Ribble Valley Borough Council
Housing & Development Control

Your ref: 3/2022/0966
Our ref: D3.2022.0966
Date: 3rd July 2023

Application no: **3/2022/0966**

Address: **Crow Trees Farm Crow Trees Brow Chatburn BB7 4AA**

**Pringle Homes - Crow Trees Farm, Chatburn**  
Accommodation Schedule

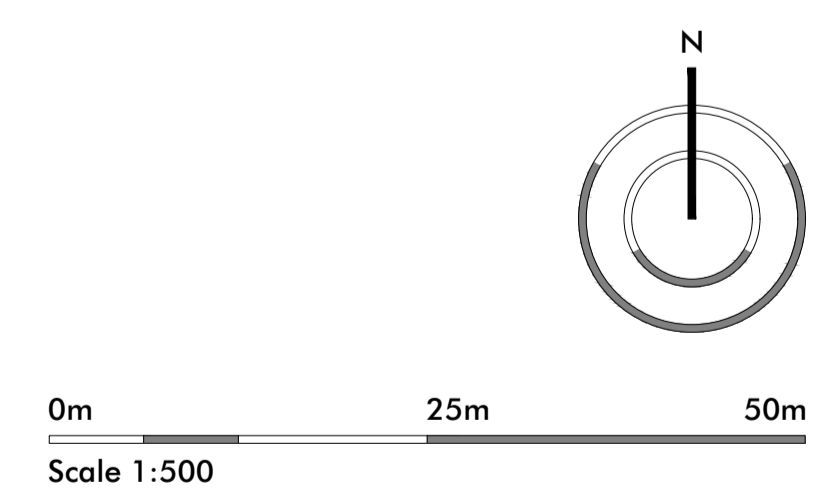
The LHA have reviewed LMP drawing number 21/139/P01 Rev C titled "Proposed Site Layout" and are aware that the site will utilise two existing accesses to serve the proposal.

The LHA have reviewed the access, as shown on LMP drawing number 21/139/P01 Rev C titled "Proposed Site Layout," and are aware that the access will be a minimum of 5.5m wide with a 6m kerb radii and 2m wide footways either side.

The LHA have further reviewed LMP drawing number 21/139/P01 Rev C titled "Proposed Site Layout" and are aware that the access can provide visibility splays of 2.4m x 63m to the north and 2.4m x 61m to the south. These visibility splays correlate with the traffic survey which was conducted between 1st-7th July 2022.

The LHA have reviewed LMP drawing number 21/139/P01 Rev C titled "Proposed Site Layout," and are aware that the internal carriageway will be 5.5m wide. To ensure that the width of the carriageway is adequate for the development, the Agent has provided Mode drawing number J32-6615-PS-004 titled "Swept Path Analysis- 11m refuse vehicle" which shows a refuse vehicle using the carriageway. The LHA have reviewed the drawing and are aware that a refuse vehicle can safely use the internal carriageway.

The LHA have further reviewed LMP drawing number 21/139/P01 Rev C and are aware that the 2m wide footway to the left of the access will terminate approximately 9m within the site. The footway will then be replaced with a 0.5m hard paved strip until the strip reaches Plot 24, when 2m wide footways are provided on both sides of the internal carriageway.

While the LHA would prefer the site to provide 2m wide footways on both sides of the carriageway throughout the site, the LHA acknowledge the constraints and so accept the proposal.

The LHA have reviewed LMP drawing number 21/139/P01 Rev C titled "Proposed Site Layout," and are aware that there are a number of grass areas independent of the Plots. The LHA advise the Applicant that the LHA will not adopt these areas and a private management company will need to maintain the areas.

2. No part of the development hereby permitted shall be occupied until such time as the access arrangements shown on LMP drawing number 21/139/P01 Rev C have been implemented in full.

4. No part of the development hereby permitted shall be occupied until such time as vehicular visibility splays of 2.4 metres by 63 metres to the north and 2.4 metres by 61 metres to the south have been provided at the site access. These shall thereafter be permanently maintained with nothing within those splays higher than 1 metres above the level of the adjacent footway/verge/highway.

8.The development hereby permitted shall not be occupied until such time as the parking and turning facilities have been implemented in accordance with LMP drawing number 21/139/P01 Rev C. Thereafter the onsite parking provision shall be so maintained in perpetuity.
